Our Ref: R/131/17/PL

**Town & Country Planning Act 1990 (as amended)
Town and Country Planning (Development Management Procedure) (England) Order 2015
Application for Planning Permission**

Development 6No. one bed apartments - This application affects the character and appearance of the Rustington Conservation Area.

Location Land Adjacent Abbots Lodge 85 The Street Rustington

SITE PLAN SCALE 1:200 @ A3

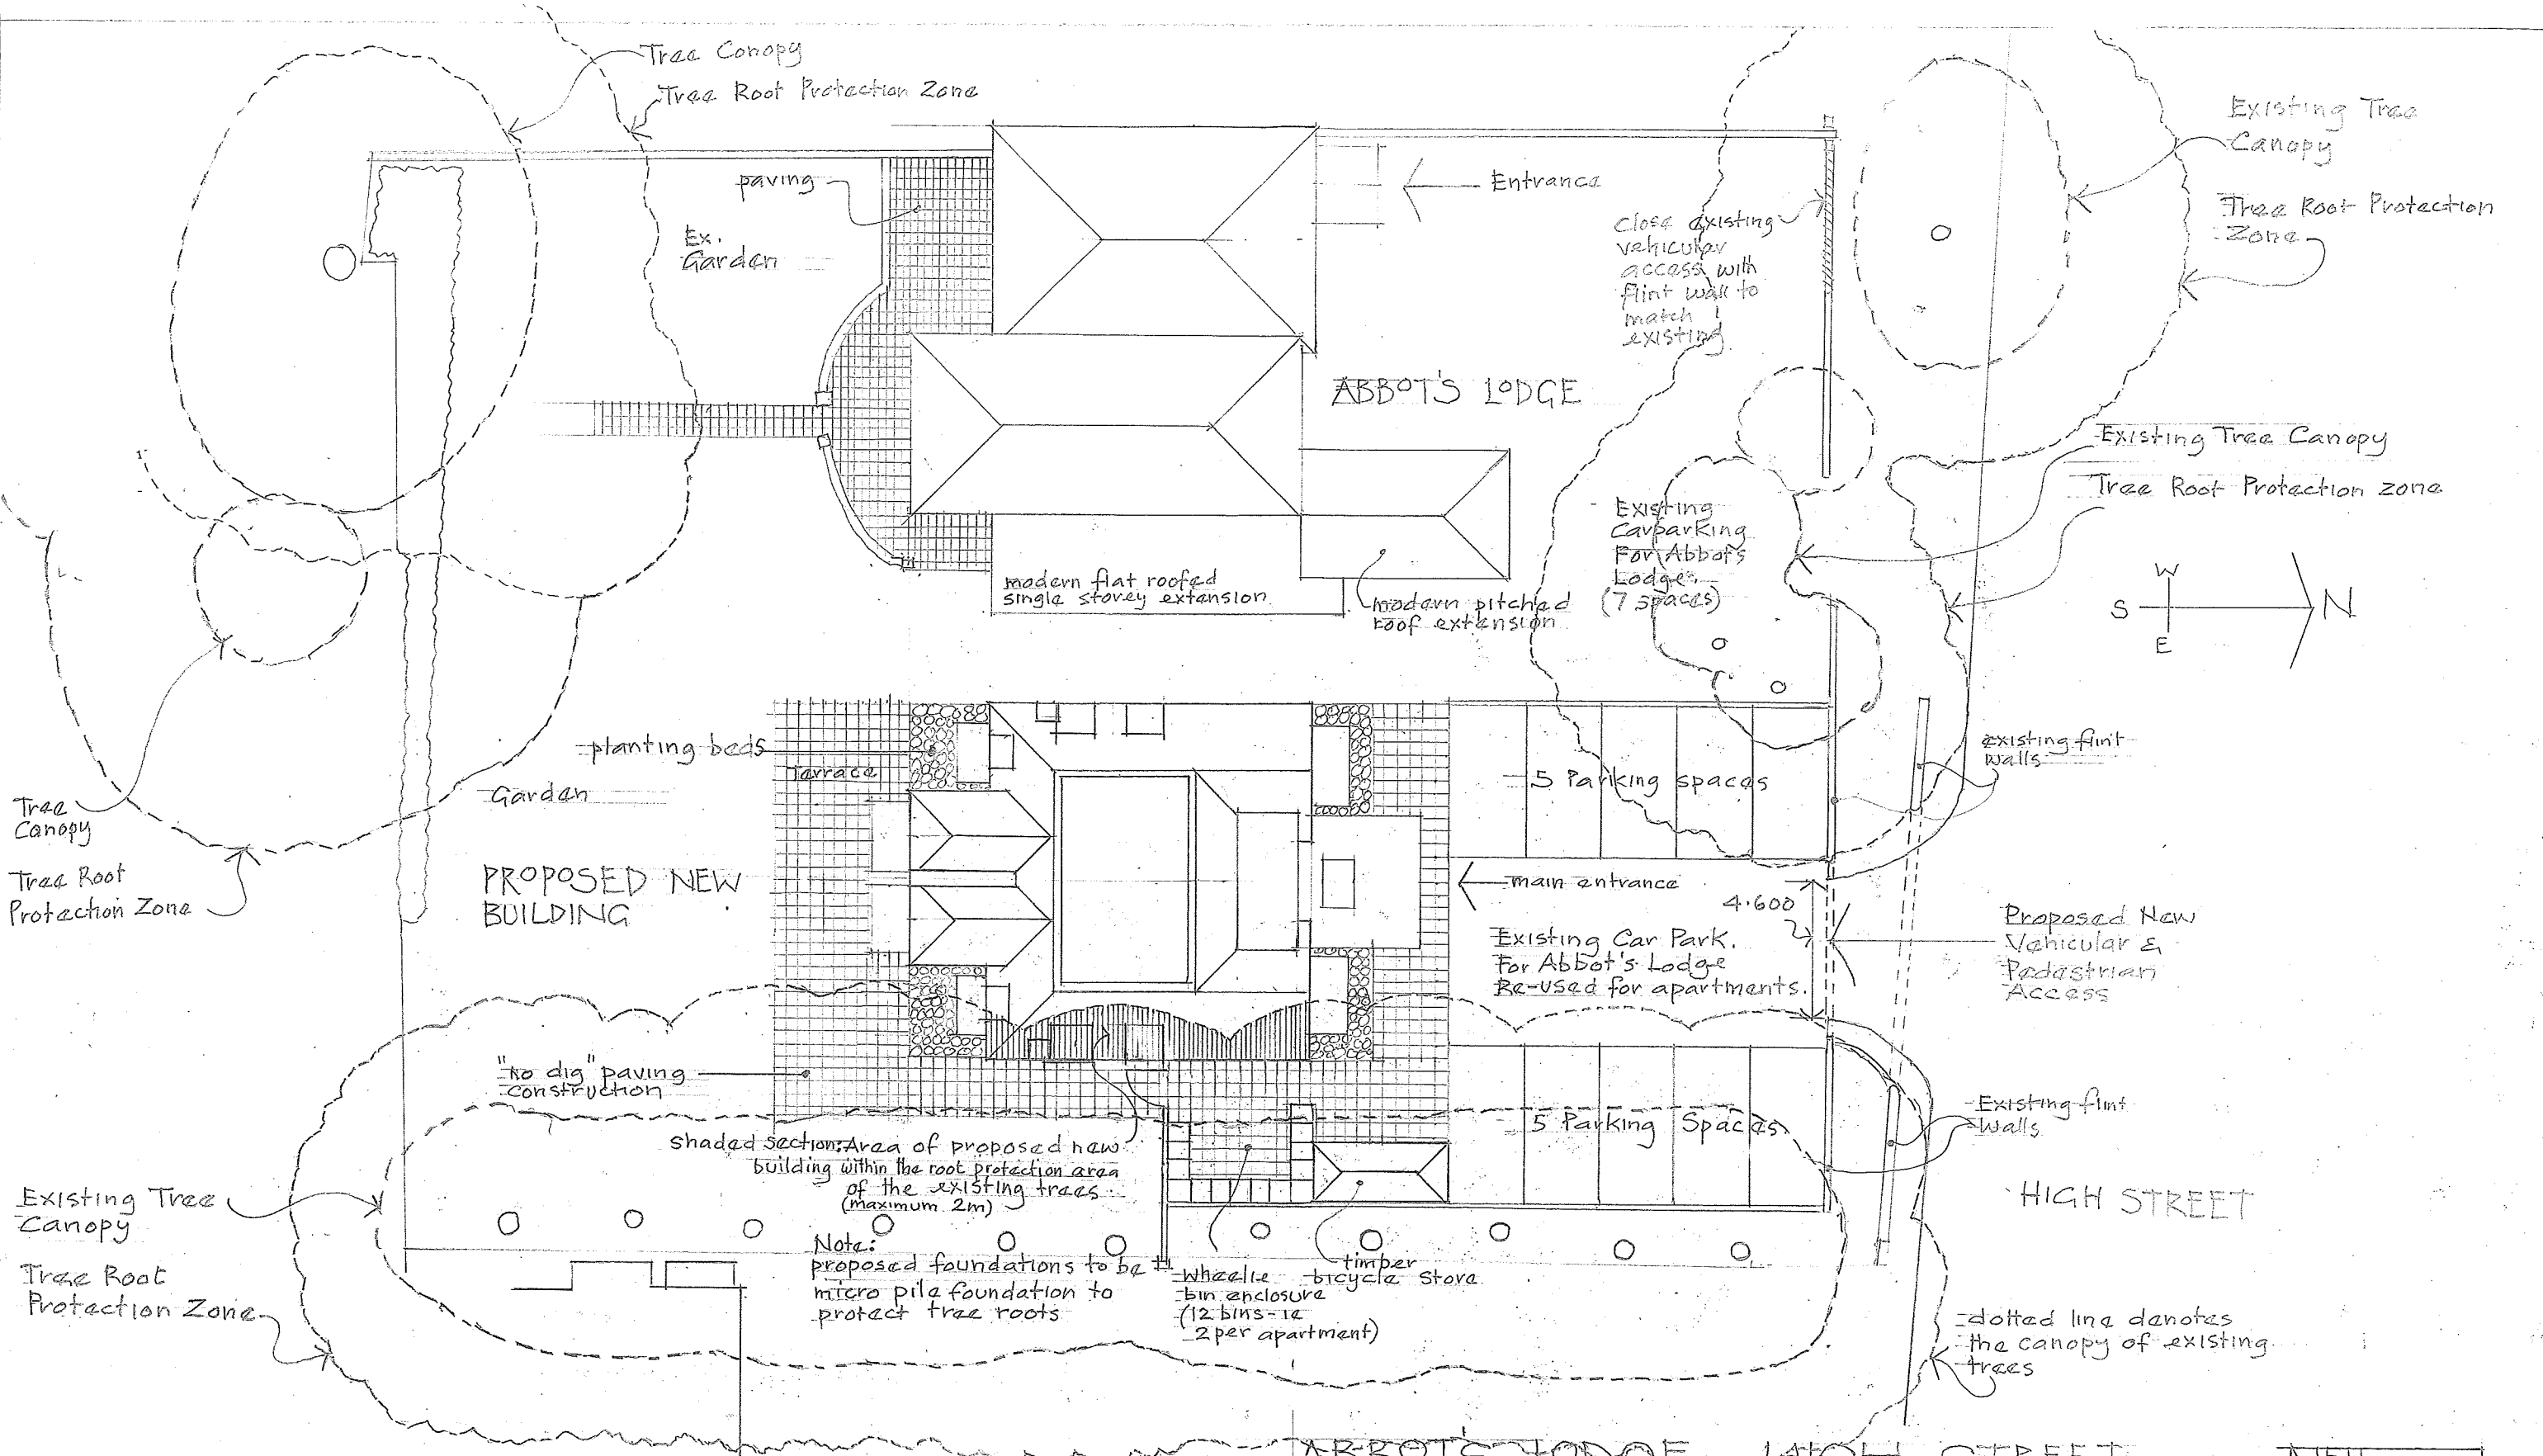
Please submit 1 electronic or 3 paper copies of an amended block/site plan at a scale of 1:500 or 1:200 to include the amended site area & new access & splays

Ordnance Survey © Crown Copyright 2017. All rights reserved. License number 100022432. Plotted Scale - 1:1250

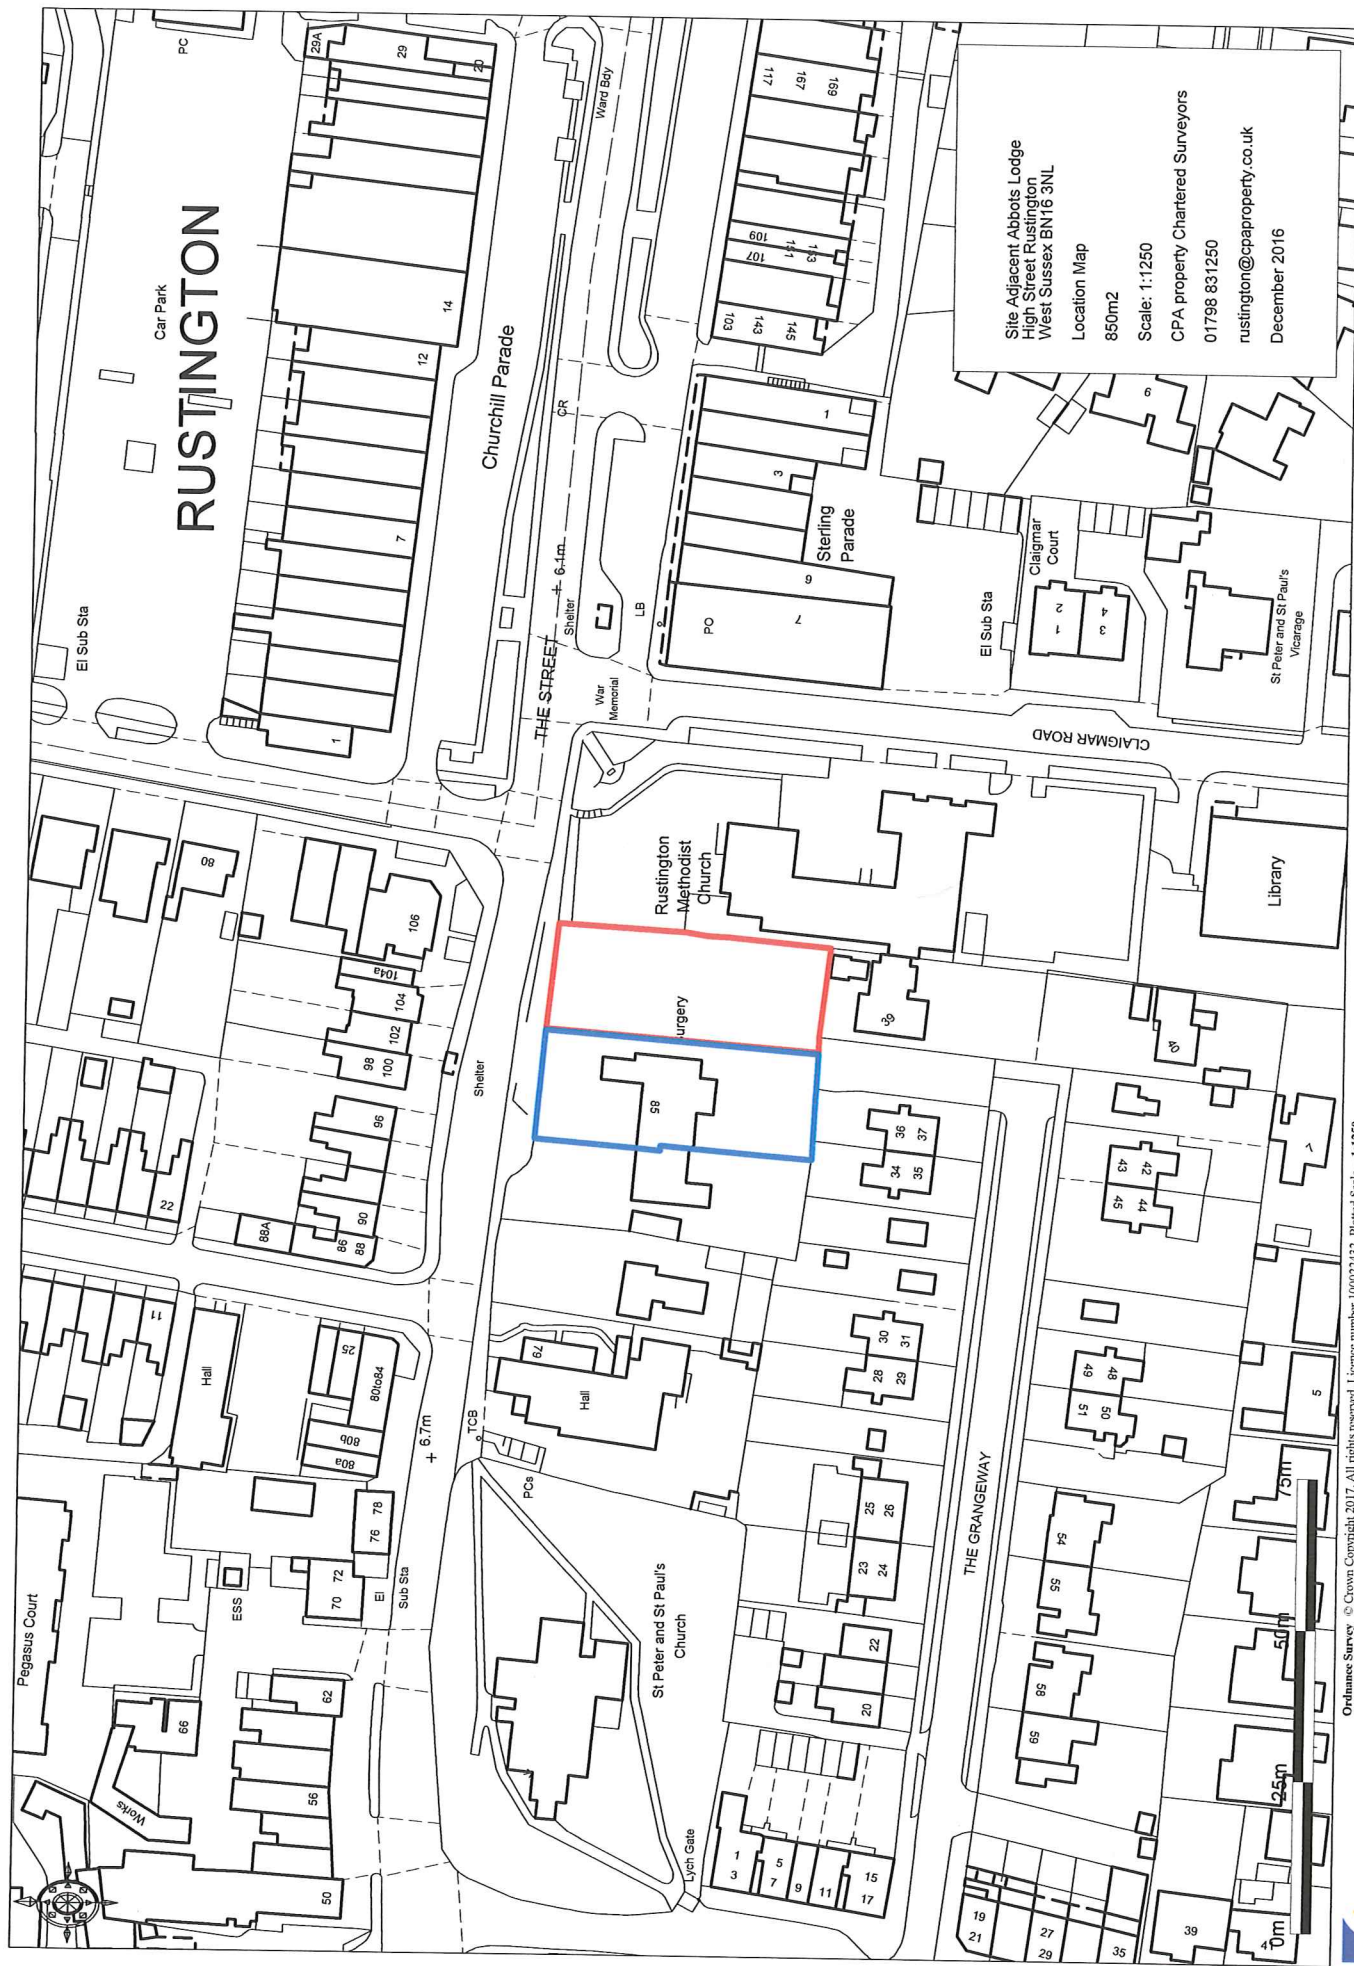
The new access will include land not owned by yourself. Therefore, please submit 1 electronic or 3 paper copies of an amended location plan to show the revised edging to incorporate the land not owned by yourself which includes the land being used for the access.
